Appeal Decision

Appeal Ref: APP/R5510/D/24/3337503

23A Frays Avenue, West Drayton UB7 7AF

Title :
Proposed Elevations
Section XX

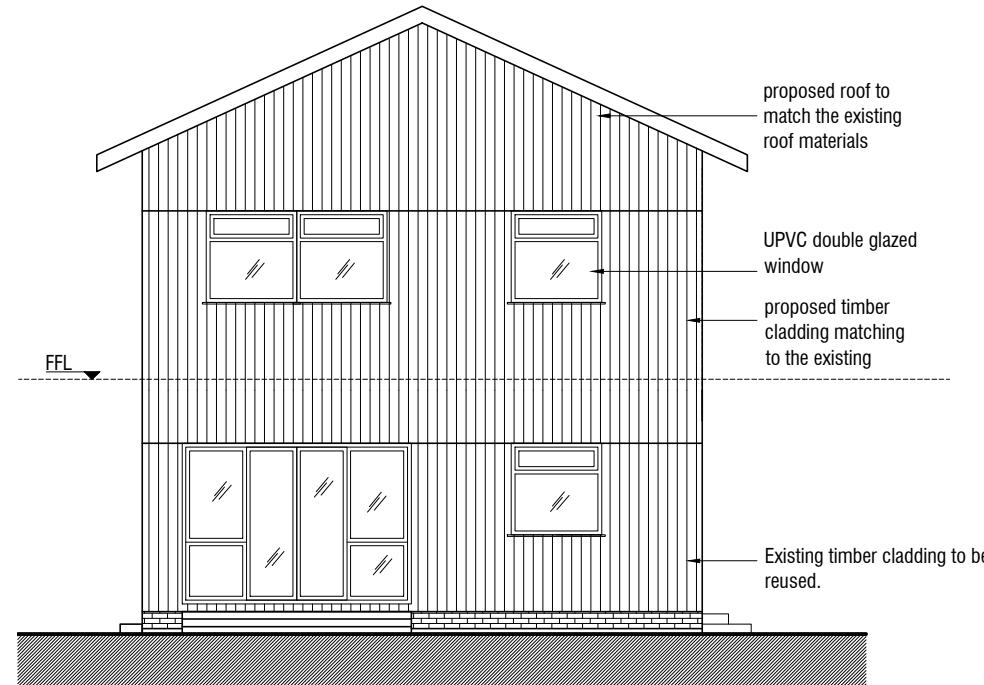
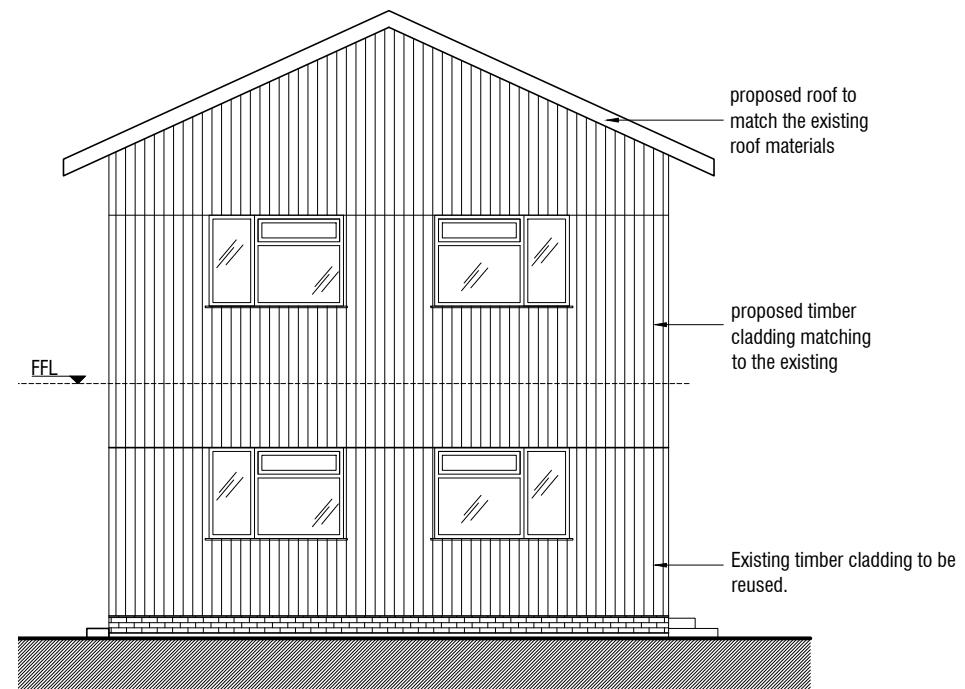
11. The proposed works would extend the appeal dwelling vertically. It would have a new roof of a similar simple pitch to the existing one and in the front and rear (shorter) elevations it would have a cohesive fenestration arrangement. The proposed new storey would not exceed 3.5m in height and would not have any windows in its flank elevations. As noted by the Council, the external finish would match the existing with the use of timber. Protected trees would not be affected.

12. The resulting building would continue to have a 'cabin' type appearance albeit of two storeys. The style would be in harmony with its semi-rural riverside surroundings and the timber exterior would fit in with the existing garden trees and riverside setting. It would not be uncharacteristic, unduly prominent or incongruous and would continue to respect the established sense of place.

Title : Proposed Elevations

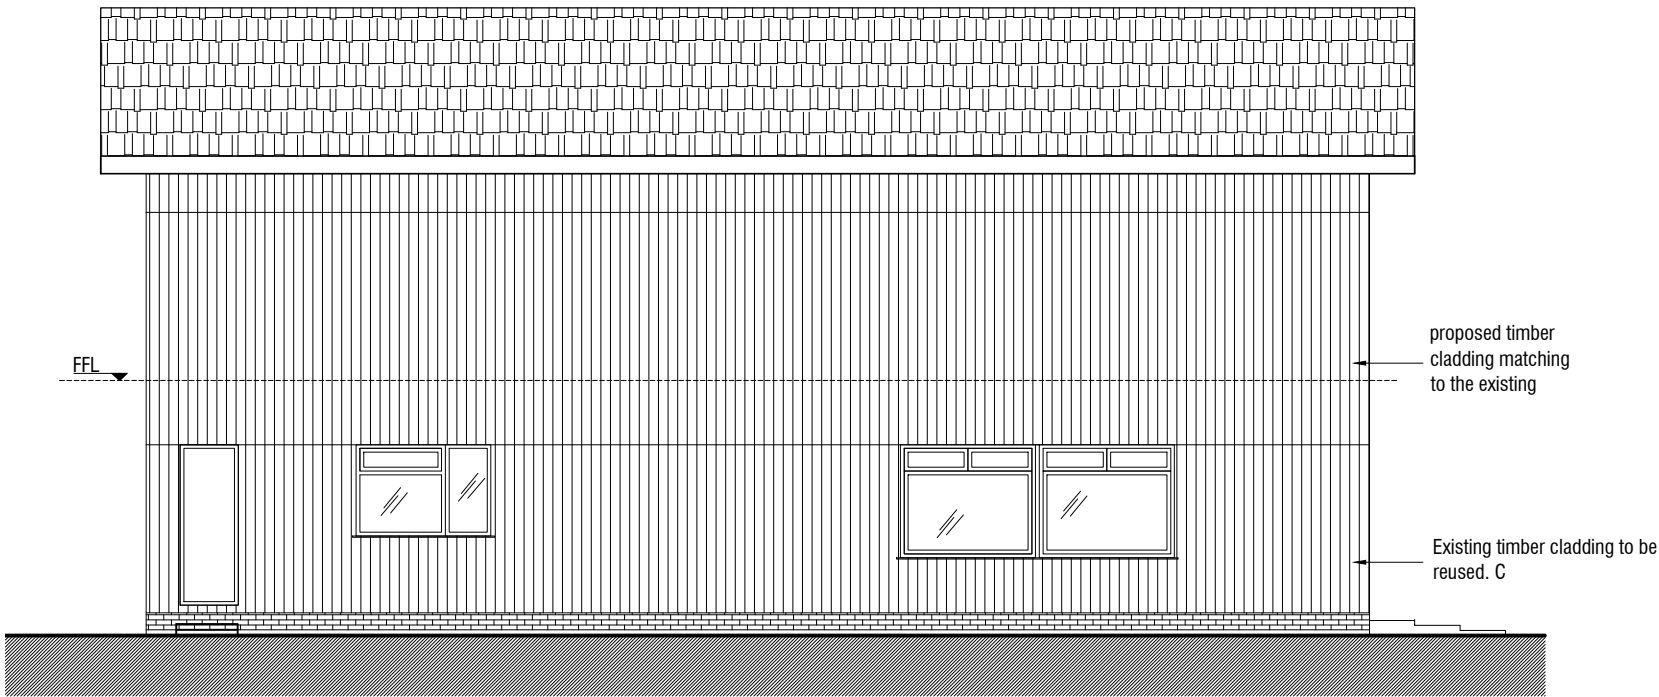
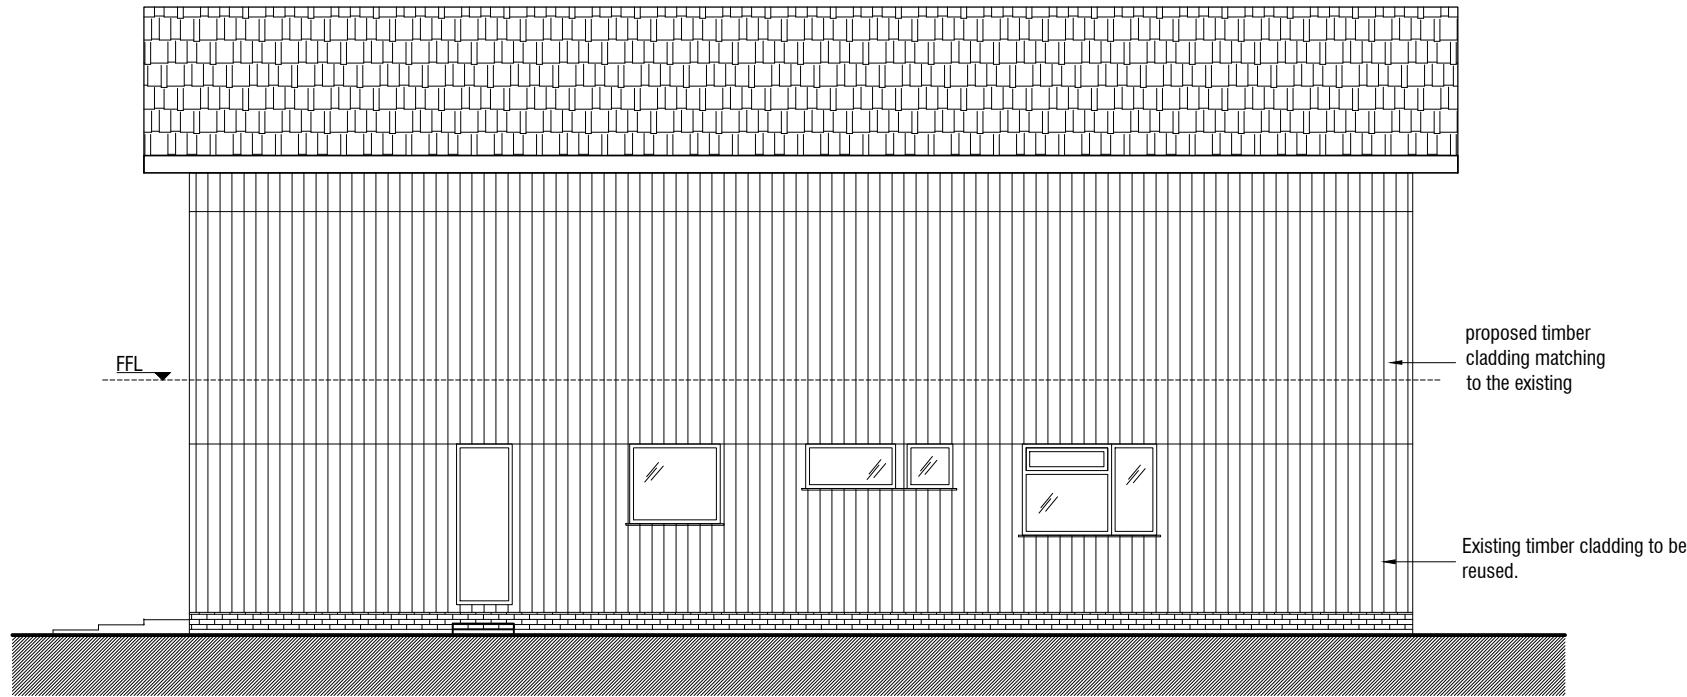
15. Class AA.2(3)(a)(i) indicates that prior approval applications should have regard to any potential impacts on amenity of adjoining premises including overlooking, privacy and loss of light. The resulting building would not have windows in its upper storey flank elevations and the new gable end windows would be comfortably separated in distance from the gardens and windows of surrounding dwellings, making any overlooking or loss of privacy for nearby occupants untenable. The generous separation distances would also prevent the new storey from blocking any daylight or sunlight from surrounding dwellings or their gardens and they would ensure that the resulting building would not cause an undue sense of enclosure for any neighbour. I have concluded that there would be no reduction in neighbours' amenities and I note that the Local Planning Authority raised no objection in such terms.
